ADDENDUM 5
To Contract Documents for
EYECARE MEDICAL GROUP
53 SEWALL STREET
PORTLAND, ME 04102

E.M.G. - Phase 2 Addition & Renovation

EYECARE MEDICAL GROUP
PHASE 2 ADDITION AND RENOVATION
ADDENDUM NO. 5
August 9, 2013

C3 Check-Out & Corr. - South
1/4" = 1'-0"

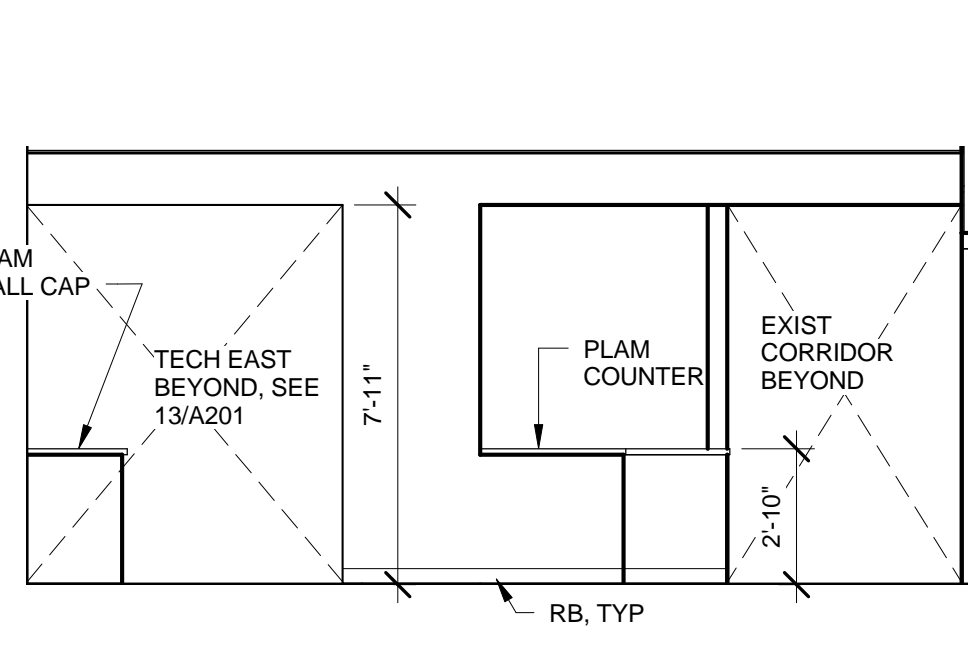
9. ADD pass-through slots at Check-Out AI22, elevation C3/A201, as shown in the attached SKA-10.
10. DELETE all glass at Reception BI01. Delete associated text and graphics on elevations B3, B4, B5, & C1 on A201.

C3 Nurse Station South
1/4" = 1'-0"

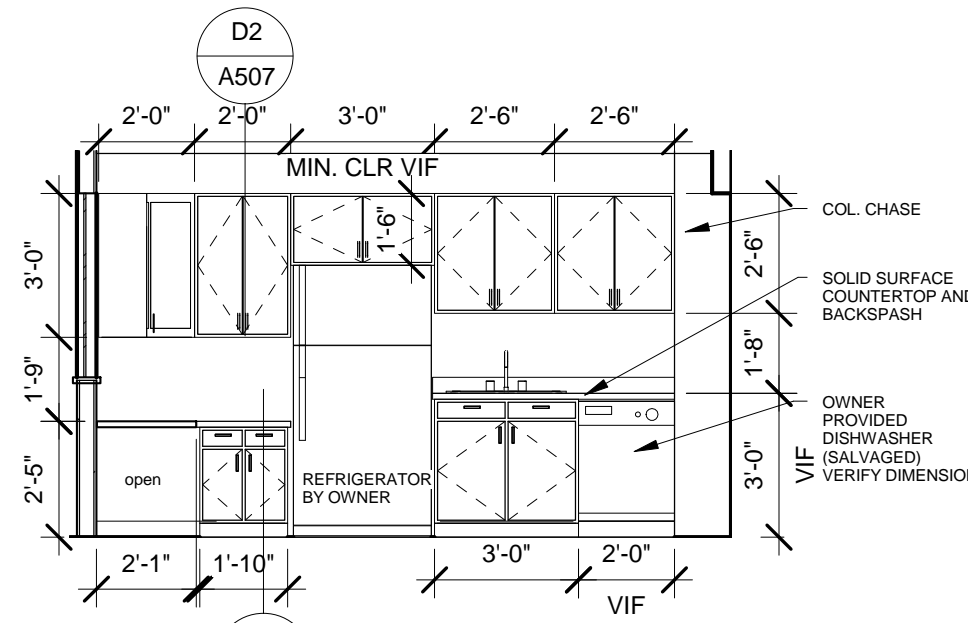
11. DELETE all glass at Nurse BI08. Delete associated text and graphics on elevations C1, C2, C3, & C5.
12. DELETE single door/drawer base cabinet shown on elevation AI/A202 for Staff Room BI02 and tag reading A3/A507. CHANGE counter and counter support configuration to include two (2) end panels in place of the cabinet. The clear width shall accommodate the Owner's under-counter refrigerator.
